Rezoning Transportation Analysis

Petition Number: #2022-105

Revision Log:

Date	Description
11-28-22	First Review (PM)
12-22-22	Second Review (DR)

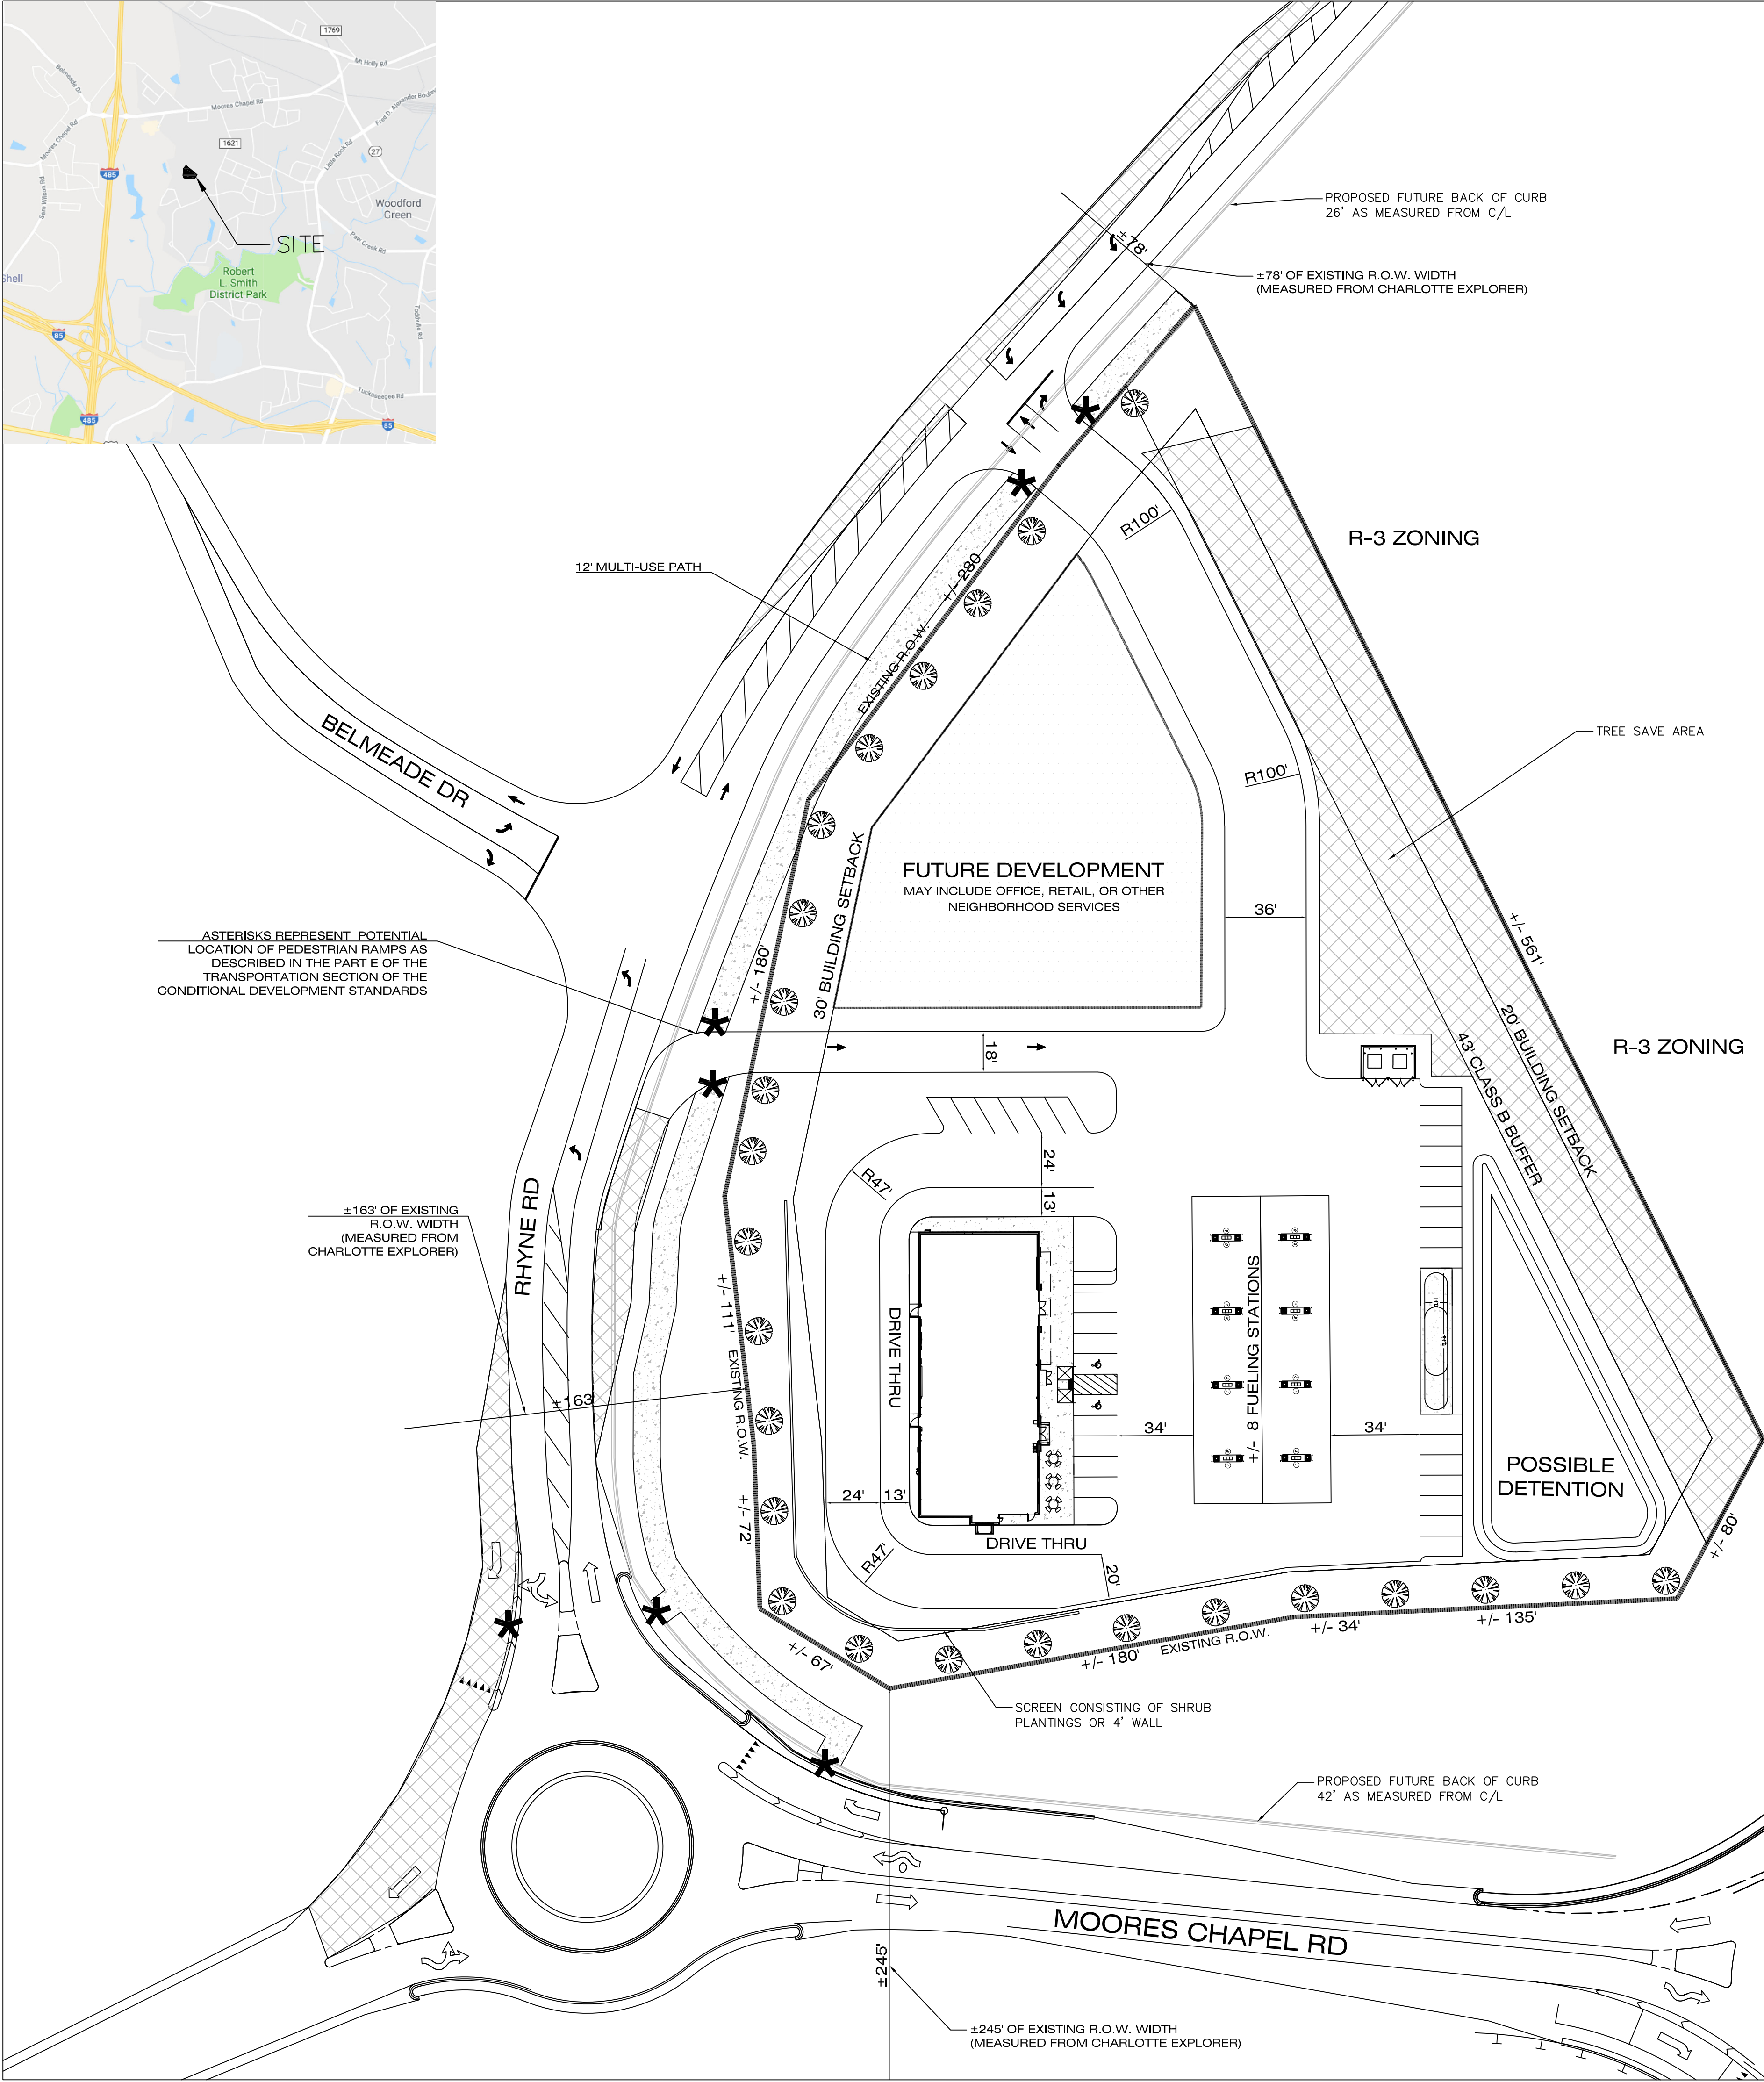
3. Revise site plan and conditional note(s) to provide 12-foot multi-use path and 8-foot planting strip along all public road frontages (Moores Chapel Road, Rhyne Road, Belmeade Drive). Revise the ramp

locations and conditional note Transportation Note E to include the additional ramps that will be required. Provide SUE located 2-feet behind sidewalk if located outside of the ROW. Add conditional note to coordinate Control of Access Break with NCDOT for proposed multi-use path along Moores Chapel Road.

Revise site plan and conditional notes to provide curb and gutter along the public roads that front the proposed tree save parcel. The minimum distance to the back of curb and gutter is 19-feet from the centerline of Rhyne Road and 30-feet from the centerline of Moores Chapel Road.

Clarifying Comment from 12/22/2022: Label and dimension streetscape along all public road frontages (12-foot multi-use path and 8-foot planting strip). Revise ramp locations as shown above and update conditional note to incorporate additional ramps. Provide SUE located 2-feet behind sidewalk if located outside of the ROW. Add conditional note to coordinate Control of Access Break with NCDOT for proposed multi-use path along Moores Chapel Road.
